From: Louise Crane
Sent: 18 May 2017 13:58
To: Planning.Responses
Subject: FW: Planning Consultation on: BR/107/17/PL

Comments from Environmental Health and Private Sector Housing:

APPLICATION **BR/107/17/PL**

Description of Works: Change of use of HMO (C4 Houses in multiple occupation) to 2
No. dwellings (C3 Dwellinghouses).

Proposed Ground Floor Plan (1/50 Scale)

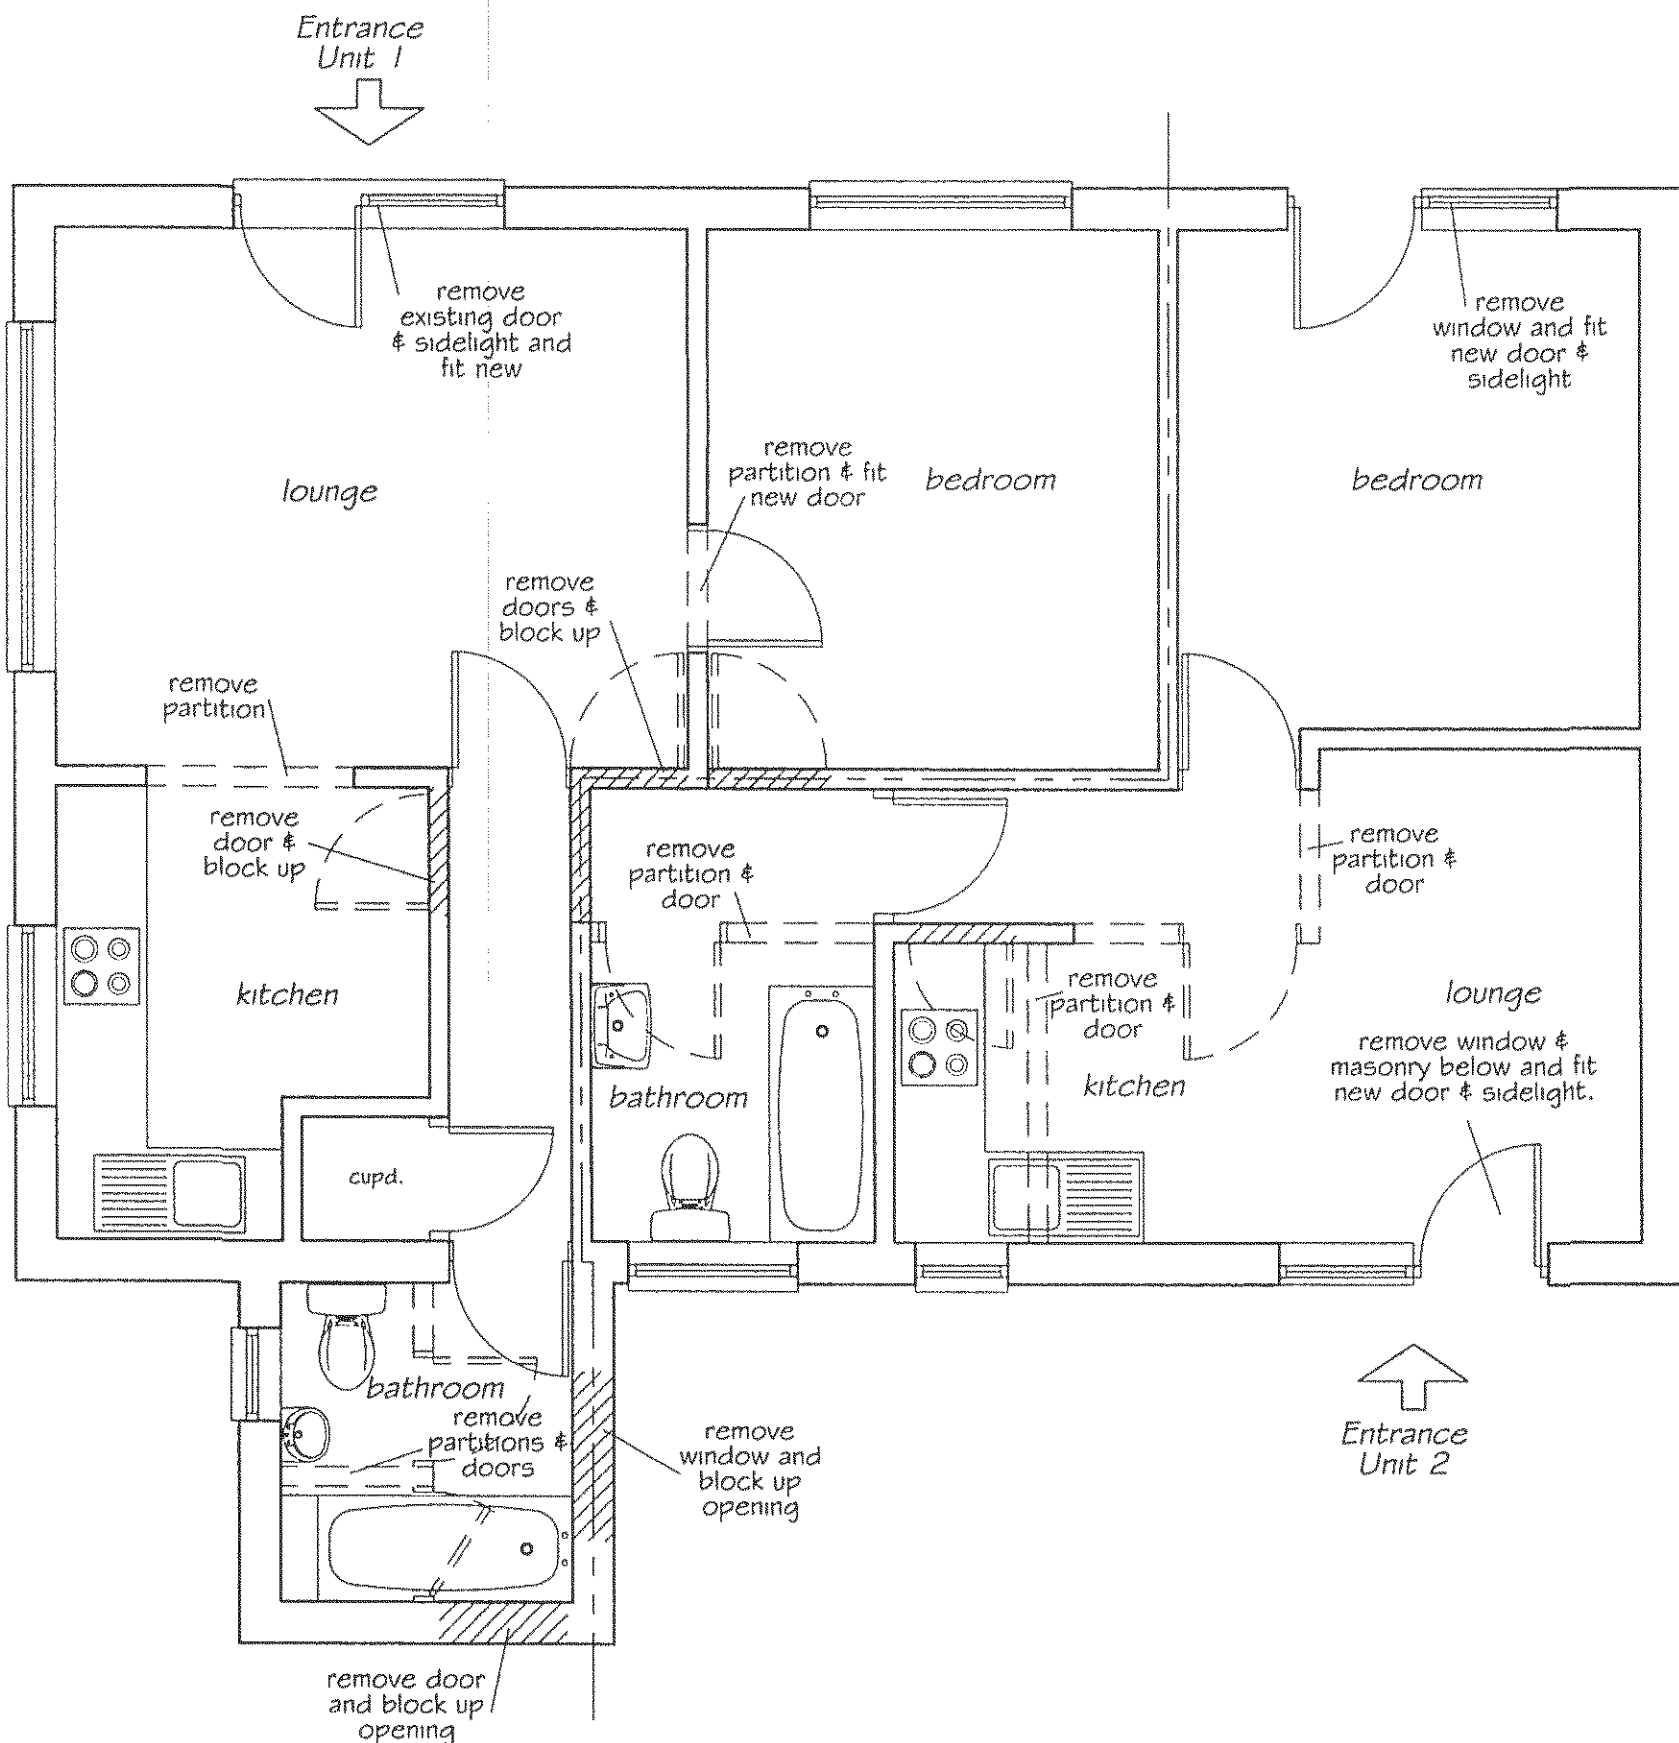
- Appropriate fire precaution facilities and equipment must be provided of such type, number and location as are considered necessary. Guidance on fire safety is contained in the LACORS guidance document – “Housing – Fire Safety, Guidance on fire safety precautions for certain types of existing housing”
- A room where the only escape route is through another room is termed an “inner room” and poses a risk to its occupiers if a fire starts unnoticed in the outer room. The escape routes from the bedroom in Unit 1 is via the Living/kitchen, this can be overcome by ensuring that the window in the bedroom is an escape window and adequate fire protection within the flat.

- Room sizes should meet the minimum standards for houses in multiple occupation if the flats are intended to be rented.
